DOC21/680463-3, EF13/3770

**Planning Referral – Advice Request
United Wambo MOD 1 – Coal Stockpiles**

I refer to your request for advice received on 9 August 2021 regarding State Significant Development Modification SSD-7142-Mod-1 (**MOD 1**) for United Wambo Open Cut Coal Mine Project –seeking to increase the existing run of mine (**ROM**) coal stockpile storage area from 6 hectares (**ha**) to 16 ha.

Figure 3-2 Phase 2 Water Management System (2020-2025)

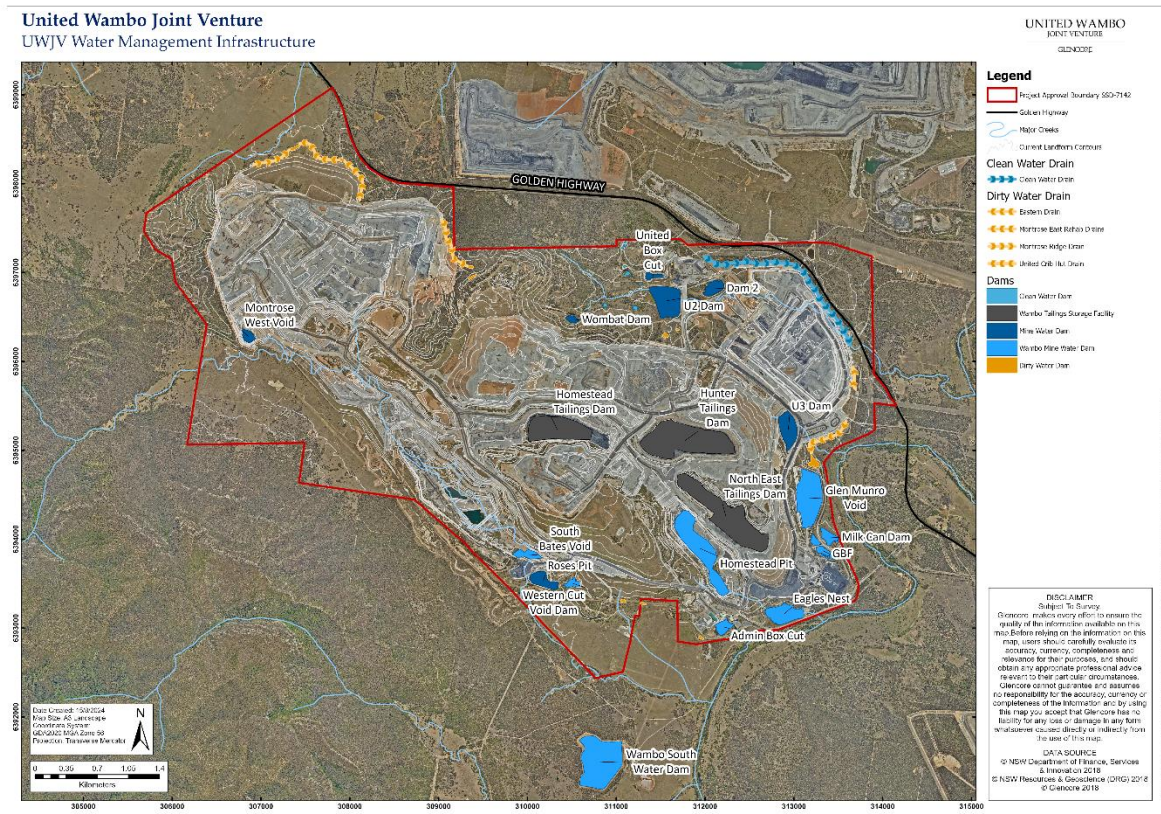
The EIS states that the proposed modification is not expected to result in a material change to the water balance for the site, however there is no discussion regarding the impacts of increased turbid runoff generated from the increased stockpile footprint. The 'Water Management System' depicted in Figure 3 of the EIS shows water flow from the proposed ROM stockpile area at United directed to the process water dam on the Wambo site which is licensed to discharge at EPA Point 4 to the Hunter River under Environment Protection Licence No. 529. The EPA notes there was a total suspended solids exceedance at this point in April 2021 and uncertainty about whether water received from United was a contributing factor.

The EPA considers further review is required to support best practice water management of the MOD 1 proposal and requests information on how water will be managed prior to entering the Wambo catchment as well as dam water pollution controls, performance indicators and incident management protocols.
